## REQUEST FOR RESPONSE TO DRAFT EIS FOR SSD 10404 STAGE 2 CONCEPT PLAN

I refer to your recent correspondence regarding the Draft environmental impact statement (EIS) associated for a proposed customer fulfillment center within Horsley Business Park at the corner of Cowpasture Rd and Trivet St, Wetherill Park.

It is noted that the proposal also forms part of a modification to the concept plan relating to the site under SSD 7446 MOD1. The following letter sets out Council's comments in relation to SSD 10404.

OVERALL SITE PLAN

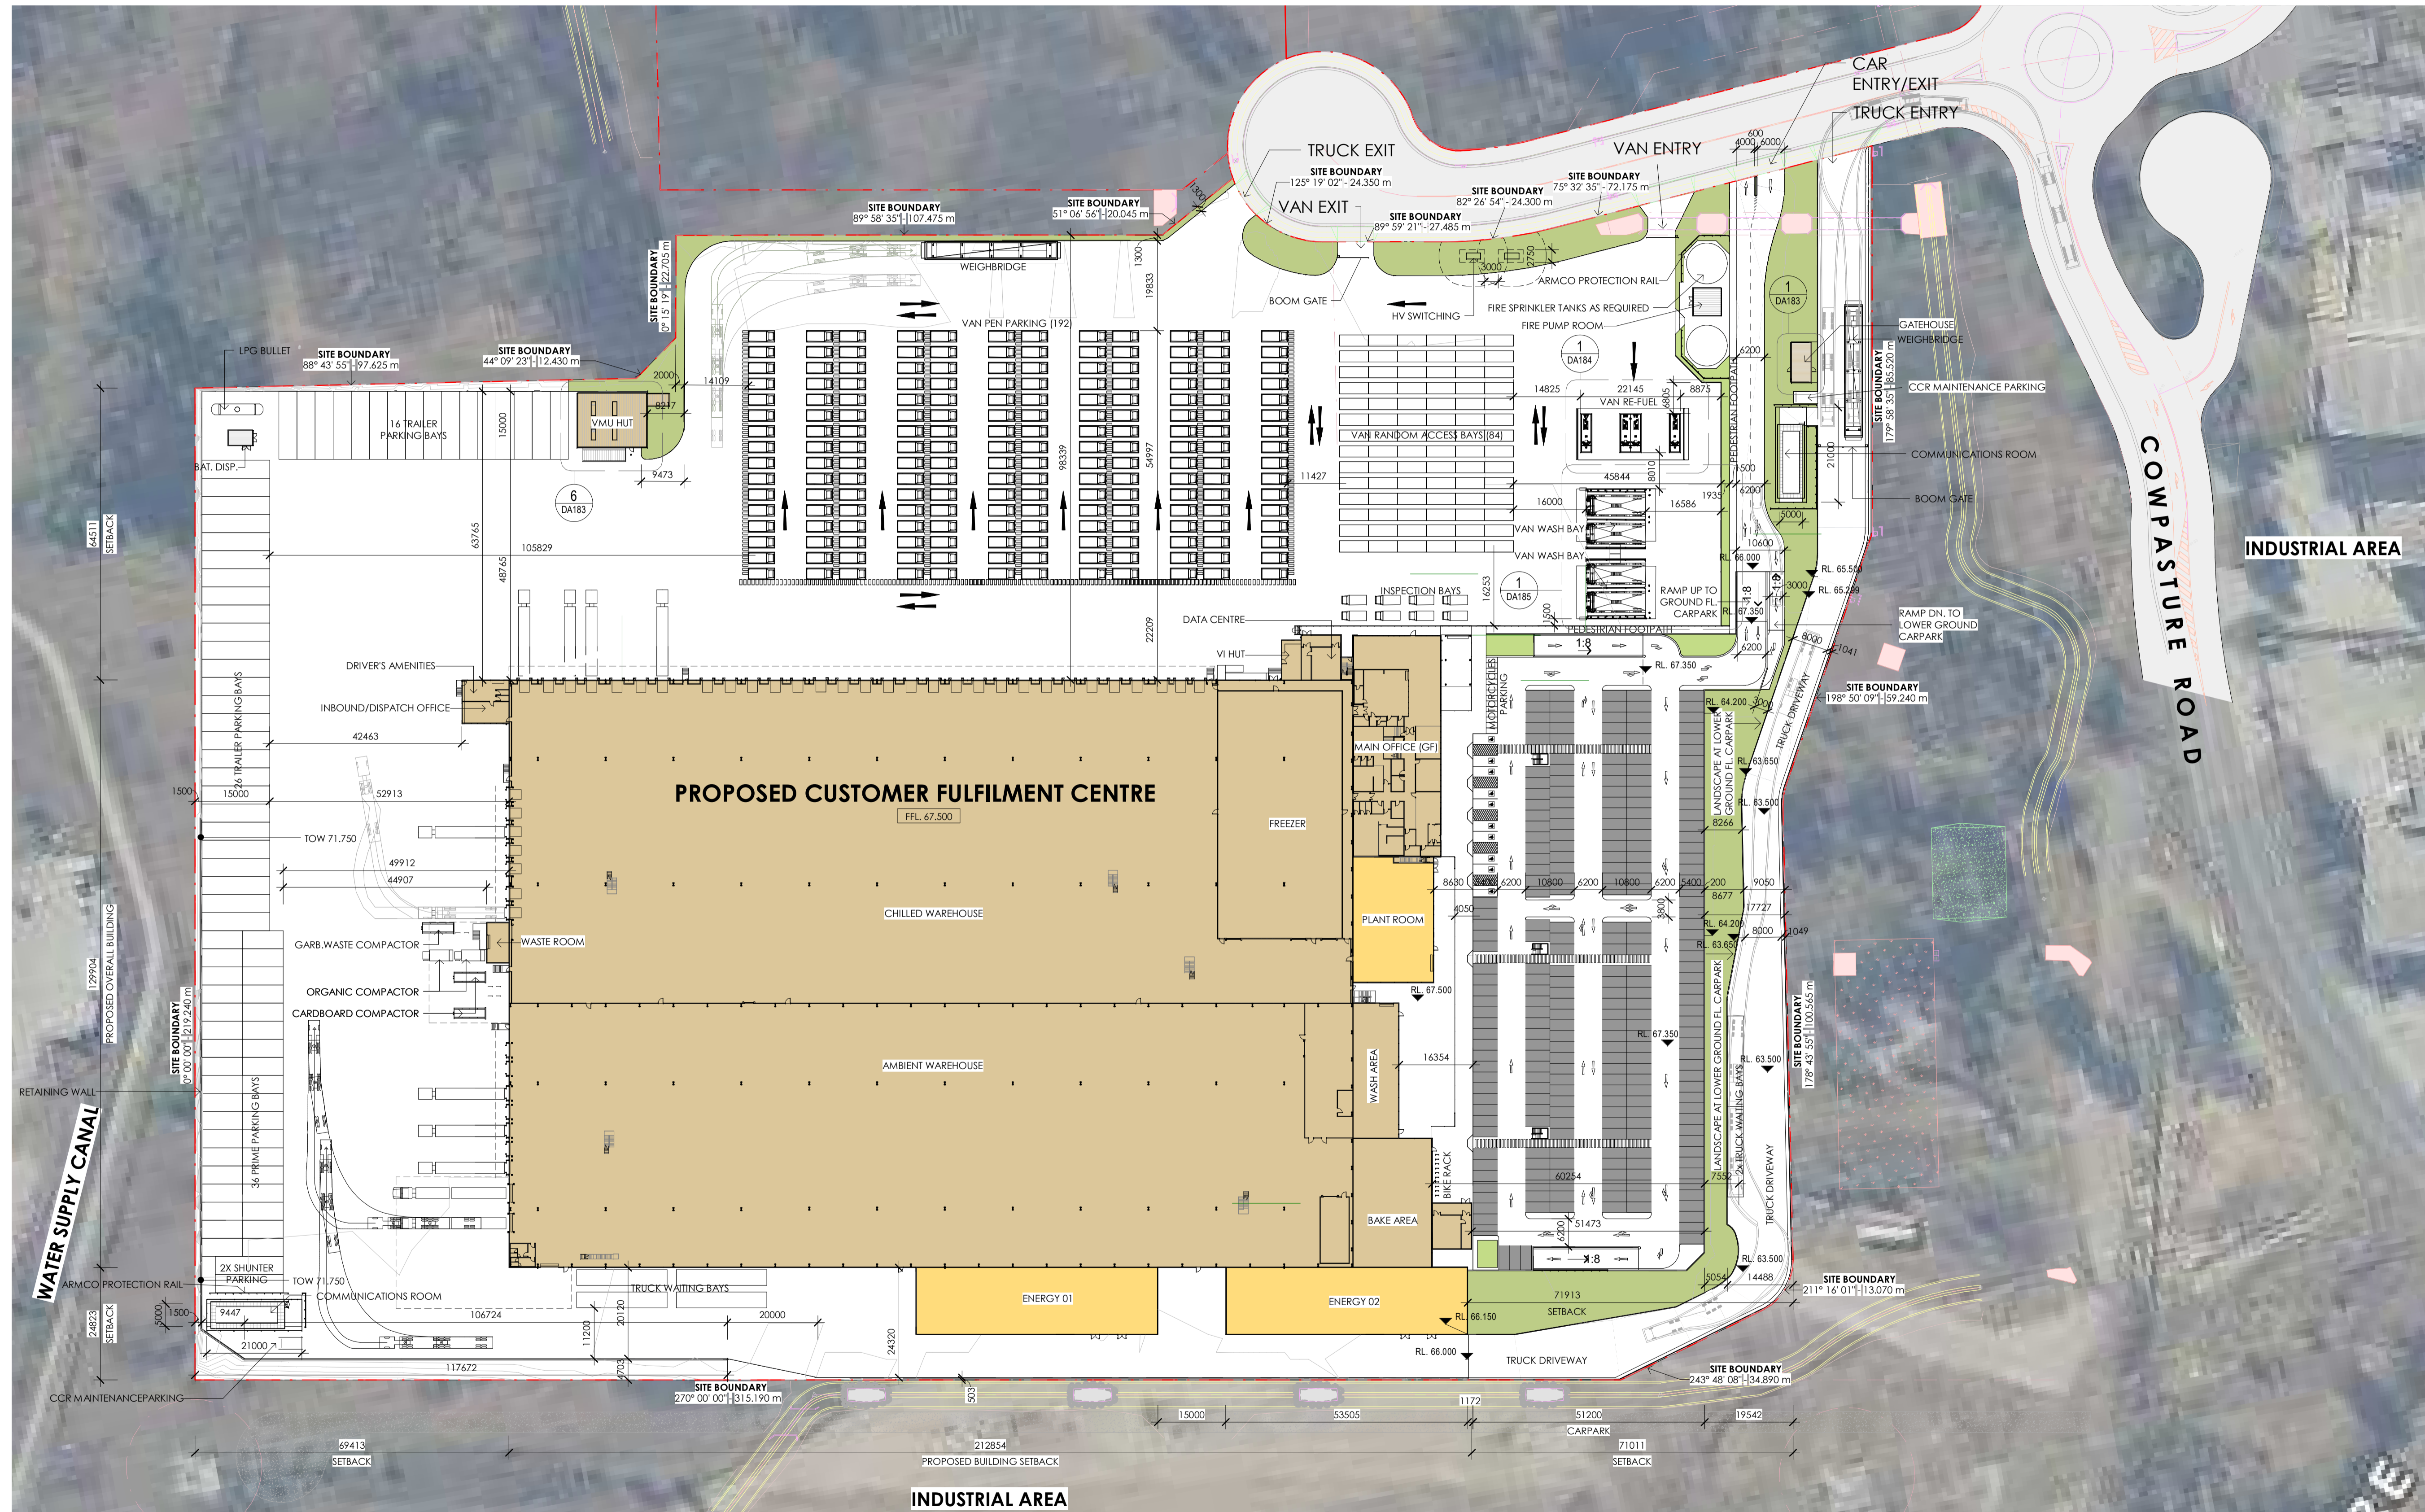
6. Clarification is required regarding the truck entry/exit driveway located at the western end of the Estate Road whether this is a combined entry/exit driveway. In addition, the proposed driveway location is directly adjacent to the driveway of the adjoining property. There will be potential conflicts between vehicles entering and exiting the two sites. The applicant shall review the location of the proposed driveway to minimise potential conflicting movements.

11. Architectural/Site plans showing the dimensions of the proposed vehicle access, internal access road width, loading bays, trailer parking bays, car parking, van parking, bicycle parking, motorcycle parking, disabled spaces and ramp grades to and from various parking and loading areas of the site shall be submitted to Council for assessment.

13. A review of the site plan indicates that parking spaces are proposed in a stacked arrangement at the south-western corner of the site. According to the Fairfield City Wide DCP, Council generally does not favour the use of stacked parking within the site unless further justification is provided. In this regard, the applicant is required to submit Council further information in regard to the management of stacked parking. The applicant shall demonstrate that the provision of stacked parking arrangement will not adversely affect the safe, efficient and effective use of the site.

VEHICLE PROFILE

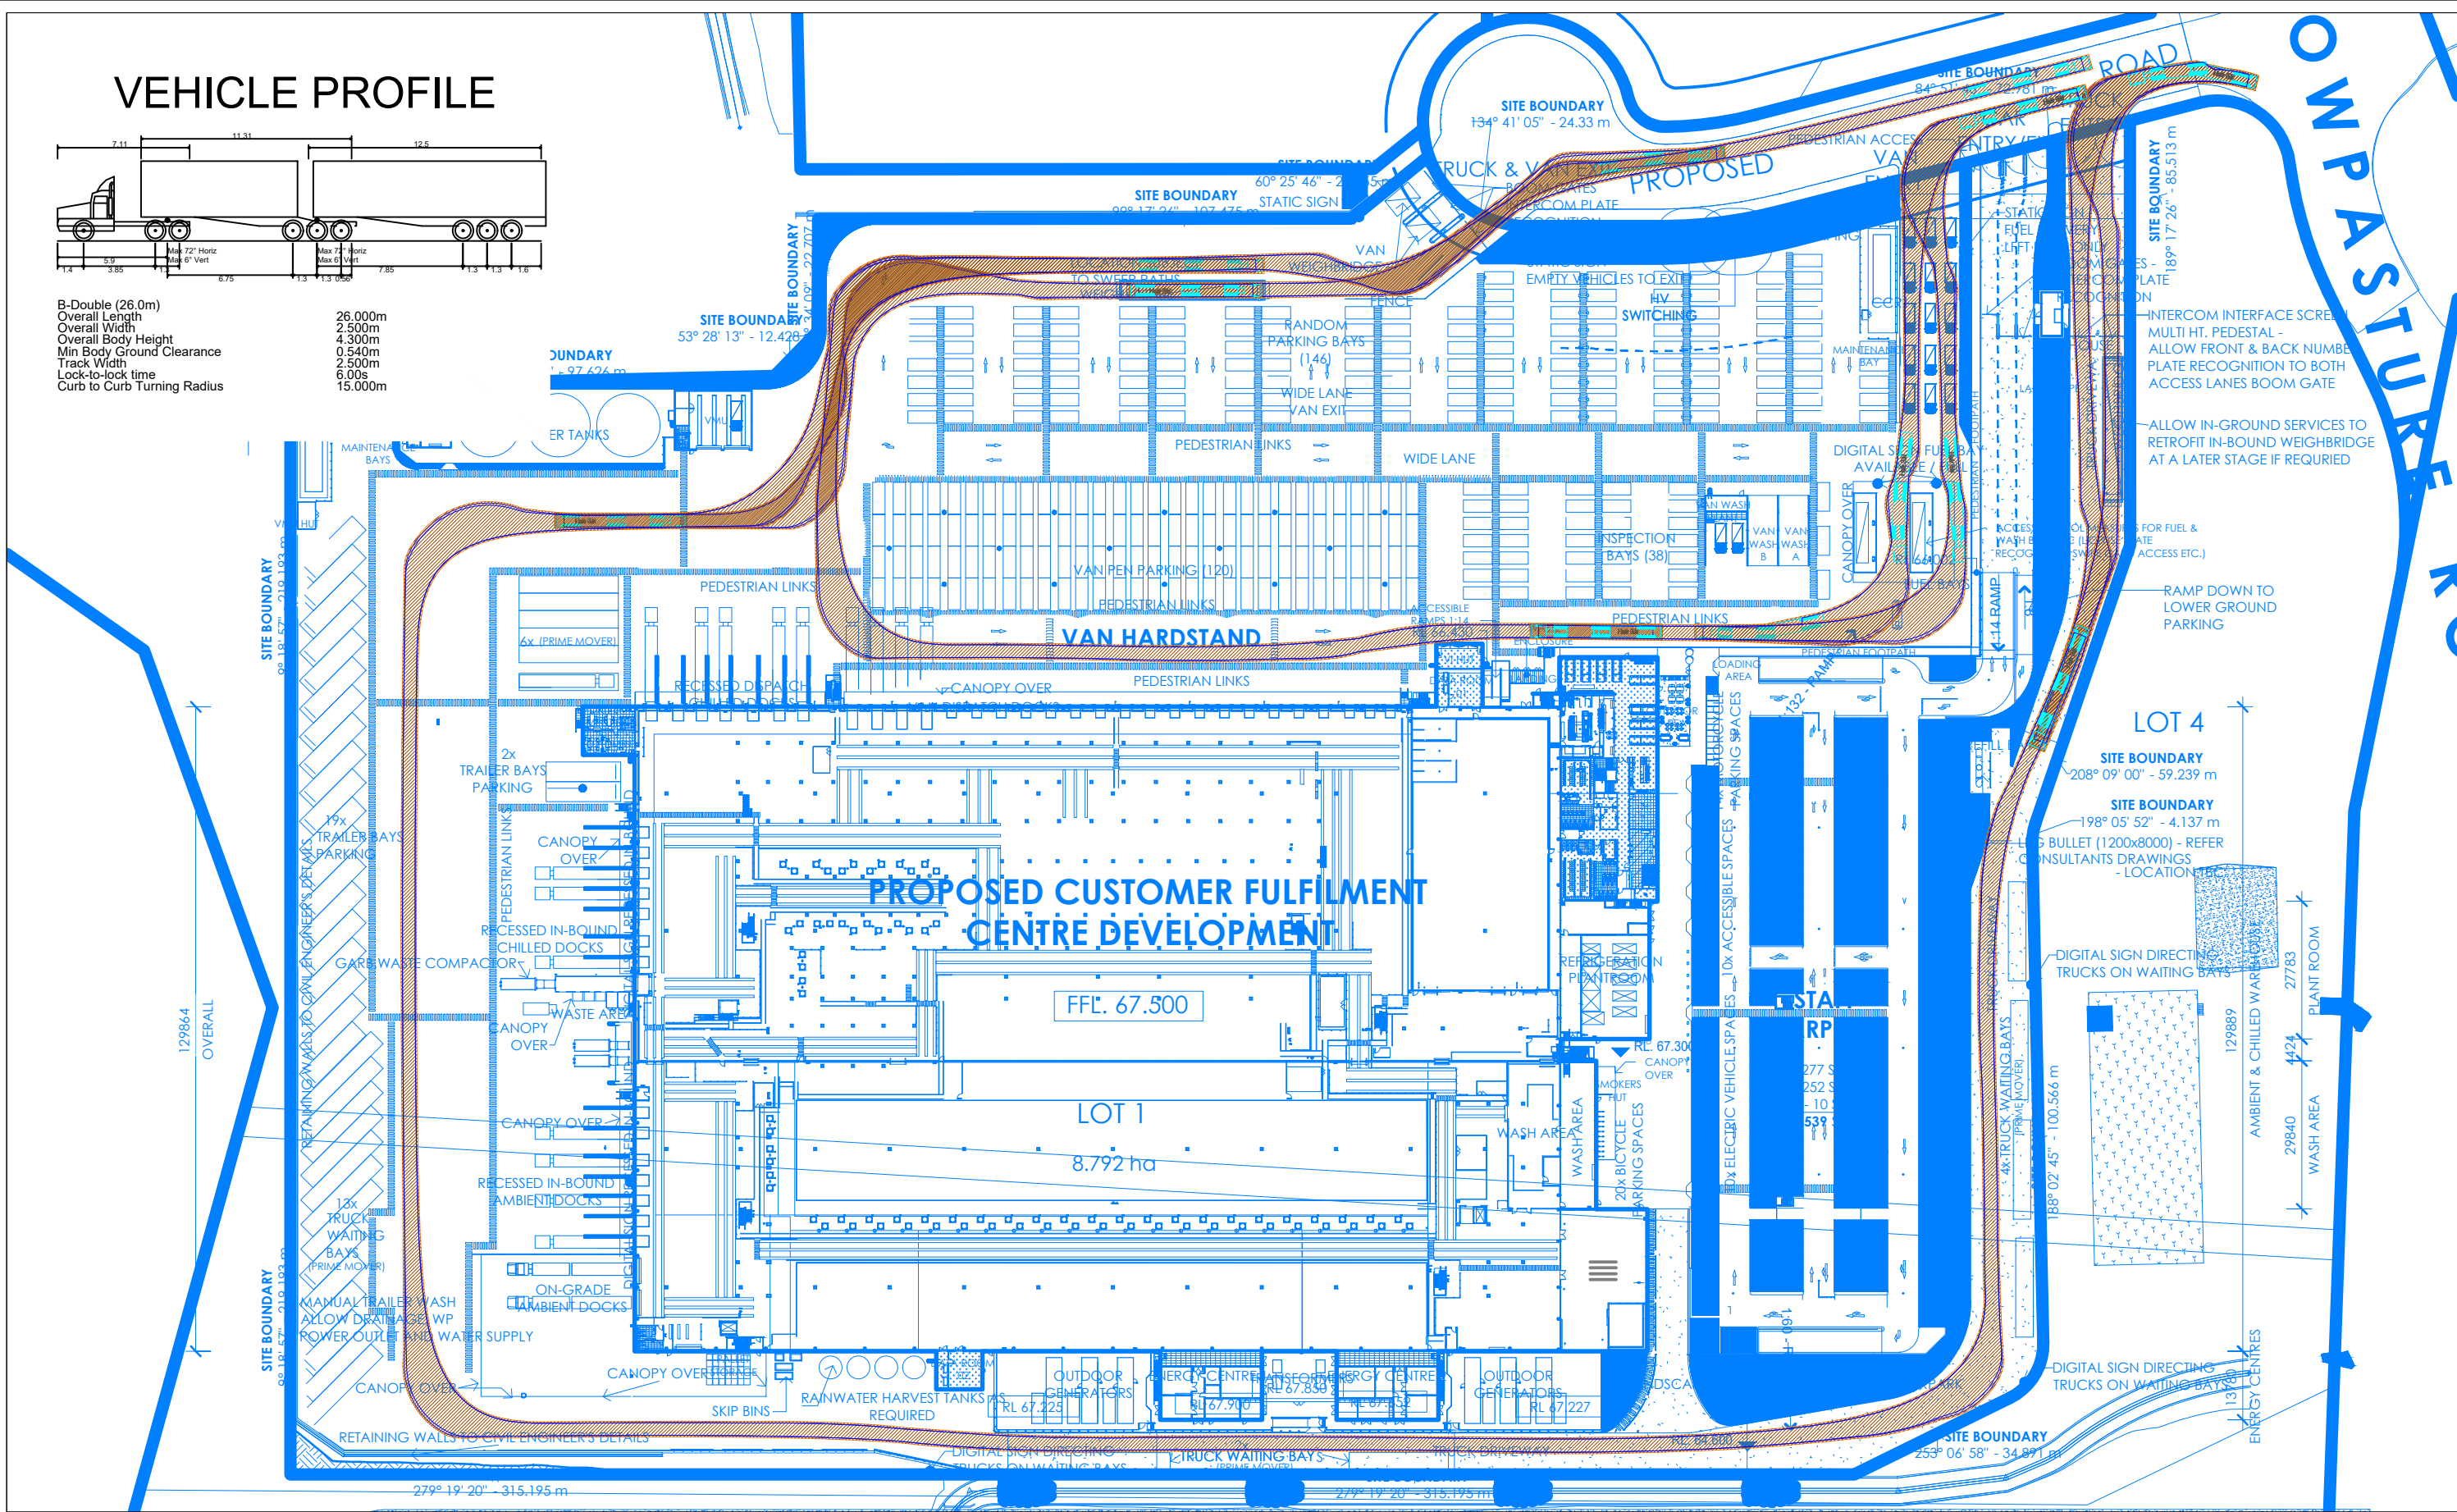
The information related to the turning path analysis is incomplete. Swept paths showing the different types of vehicles (design vehicles) manoeuvring into, within and out of the site shall be submitted to Council for assessment. Swept path analysis shall also demonstrate how the heavy vehicles can manoeuvring into and out of the loading bays.

10. No information is provided regarding the provision of designated loading bays for 26m B-Double vehicles to service the site. Service vehicles shall only undertake loading and unloading activities from the designated loading areas and shall not obstruct the car parking areas and traffic flow within the site. Additional information shall be provided to Council for assessment.
